ATP Seven

12 May 2008

Prepared for ATP Partnership Pty Ltd

Section 75W Modification to Consent No. 06_0149

Floor Plan
Level 4

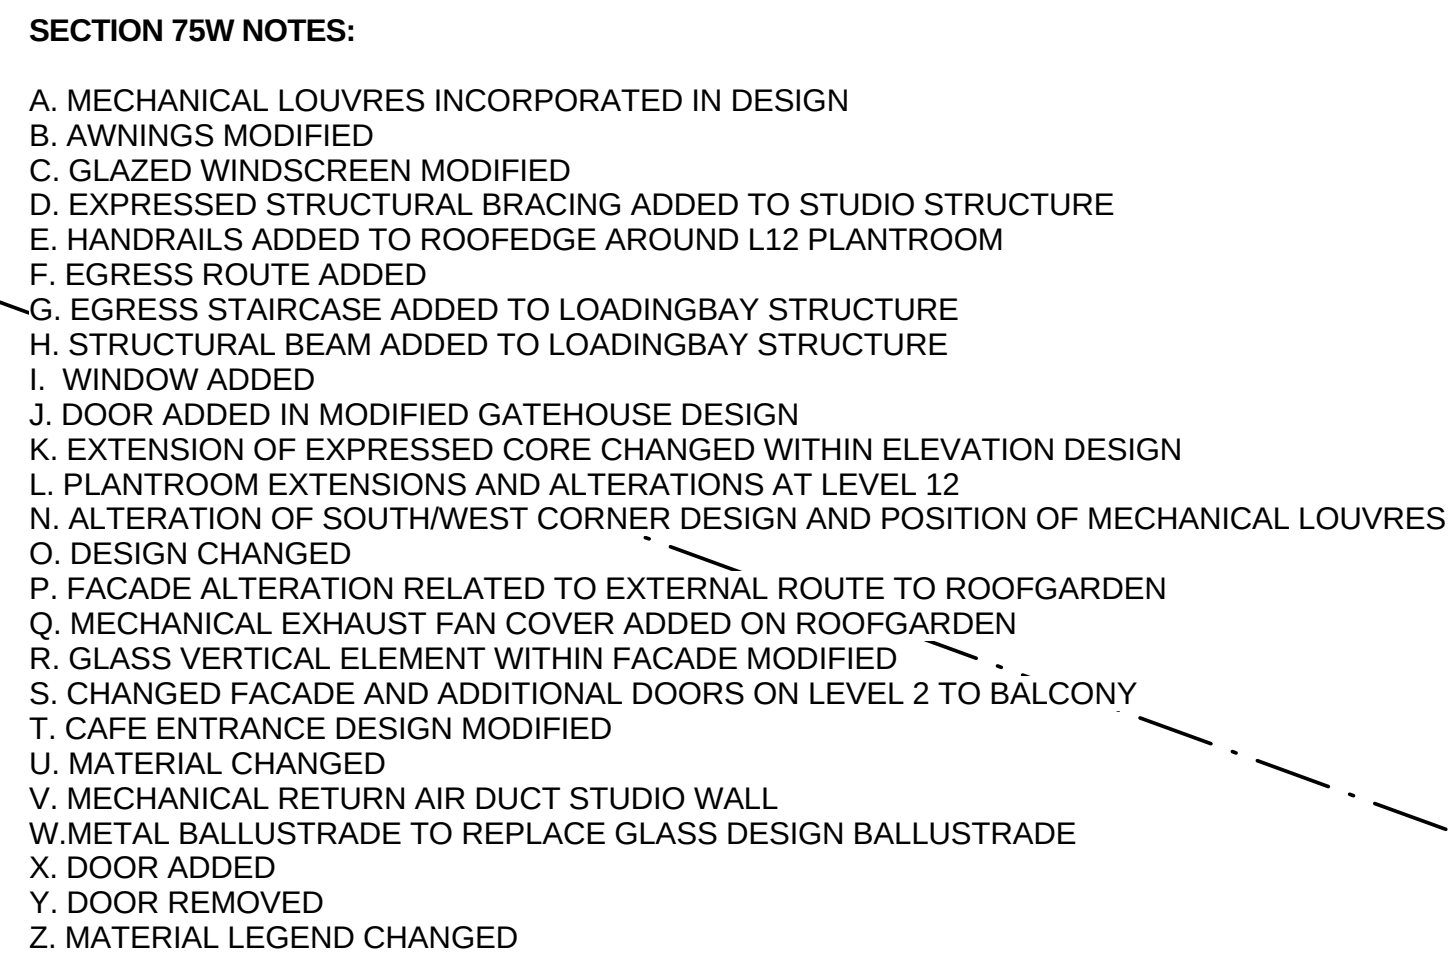
E	Handrails added to roof edge around Level 12 plant room	Required for user safety for plant room areas.	A recessive detail of the rooftop area that will not be prominent from adjacent public domain. Minor modification – low impact.
F	Egress route added	Secondary fire egress from studio plant rooms.	Minor visual impact mostly screened by canopy/awning. Minor modification.
G	Egress route added to loading structure	Fire egress required (stair connection to F above).	This fire egress is located at the rear of the building. Minor modification., low impact
H	Structural beam added to loading bay structure	Large open span to cater for truck access requires additional structural beam.	Structural beam integrated into the design of the opening. Minor modification, low impact.
I	Window added	Ground level security office at gateway requires window for increased surveillance.	Affords increased surveillance for security purposes. Minor modification, beneficial impact.

Floor Plan
Level 6-11 & Level 12

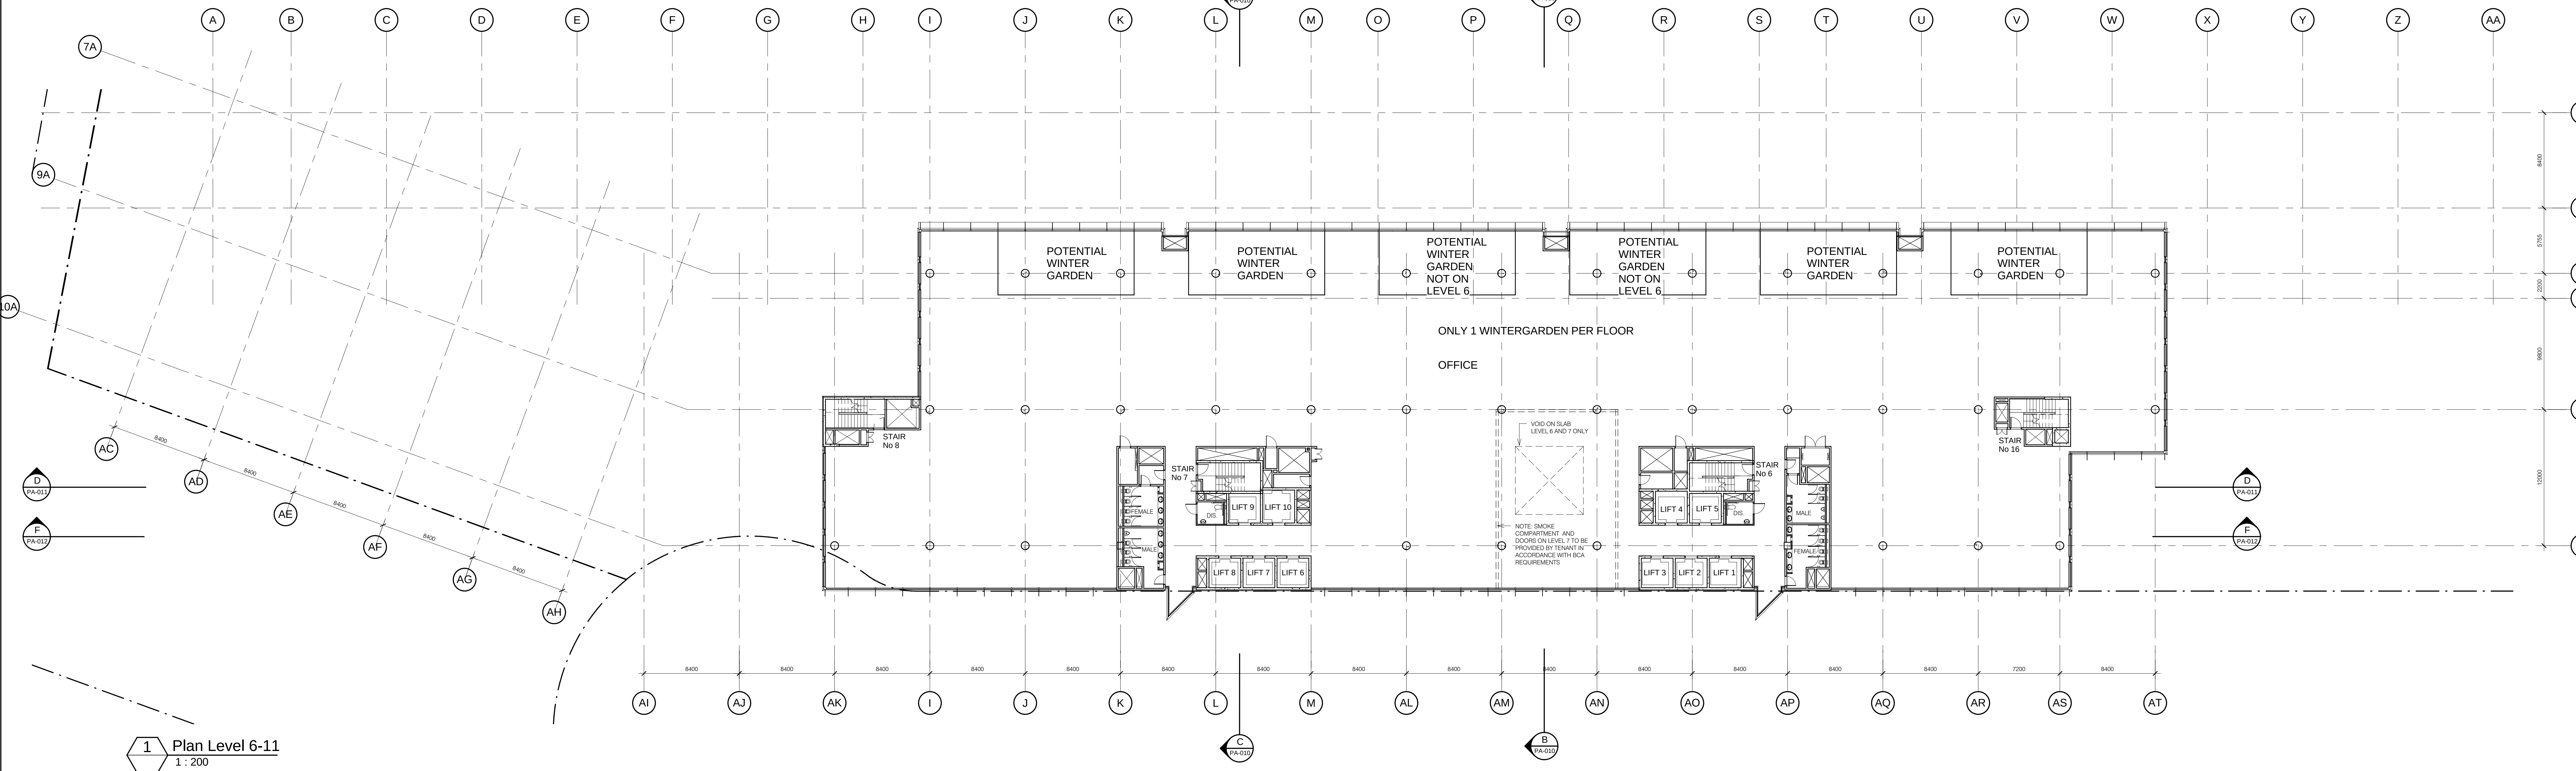
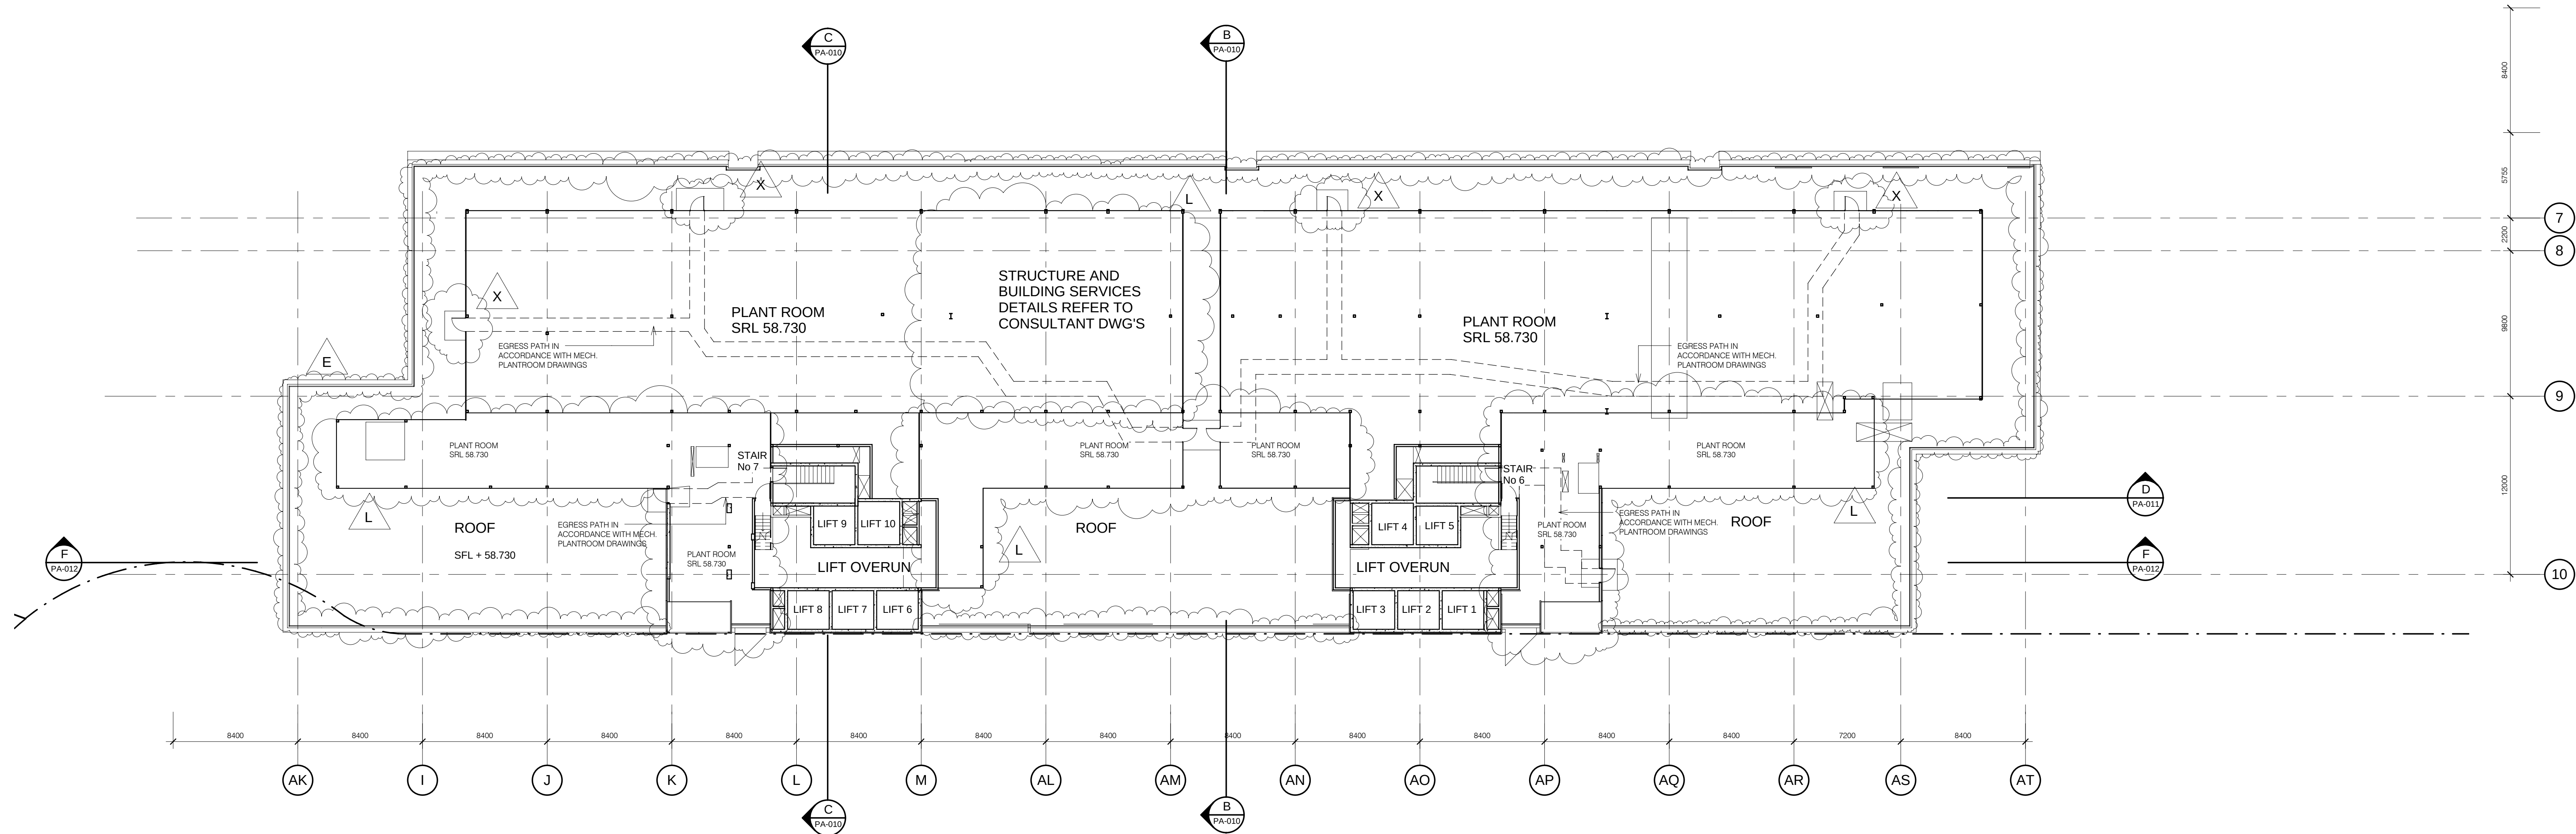
A greater volume of plant room than had been originally planned for has been made necessary as a result of a full mechanical design development, including necessary segregation of mechanical elements. Rather than reconfiguring the whole of the Level 12 plant room appearance, discrete locations have been found for the increased areas together with minor enlargements that, together, retain the overall planned silhouette of the building when viewed from the principal vantage points. These extended plant room areas generally remain beneath the canopy that comprises the plant room roof, retaining its overall original architectural resolution.

The most significant modification is the additional area/volume required for the plant room at Level 12. In this respect, the overall architectural integrity of the original design is not altered as a result and no significant impact, such as increased overshadowing to the nearby child care facility, will occur. There is also no significant bulk impact generated by the additional plant room space.

1 North Elevation
1 : 200

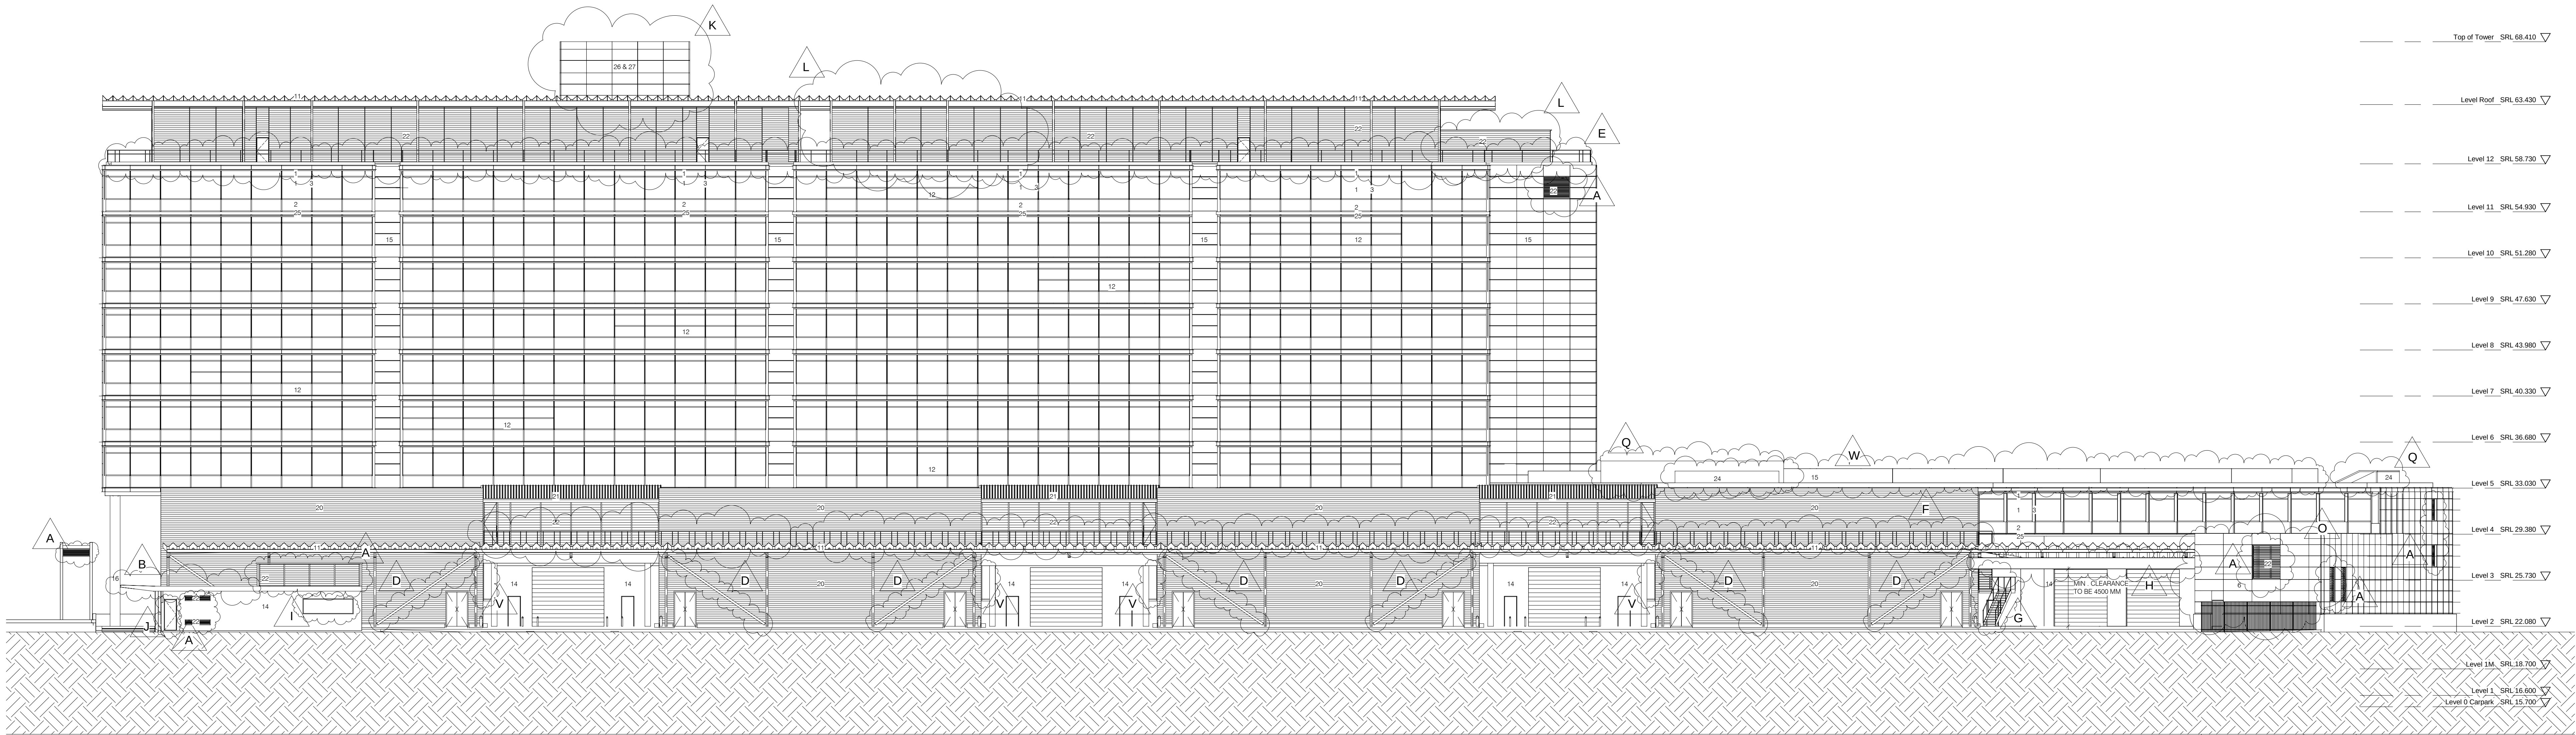
Plan and Schedule Reference	Description of modification	Justification/Objective of modification	Conclusion on impact and status of significance
K	Extension of expressed core changed within elevation design	Additional area at the side of the lift cores required for services and internal planning	Minor modification, low impact.
L	Plant room extensions and alterations at Level 12	Necessary to meet critical mechanical requirements including segregation of plant room elements.	Enlarged plant room remains setback from edge of building and canopy. No significant visual or overshadowing impact. Minor modification. See Section 2.
N	Alteration of south west corner design and position of mechanical louvres	Structural integrity of southern wall makes relocation of louvers necessary (openings in southern wall not permitted)	Relocated louvres are consistent with others as approved elsewhere. Minor modification, low impact.
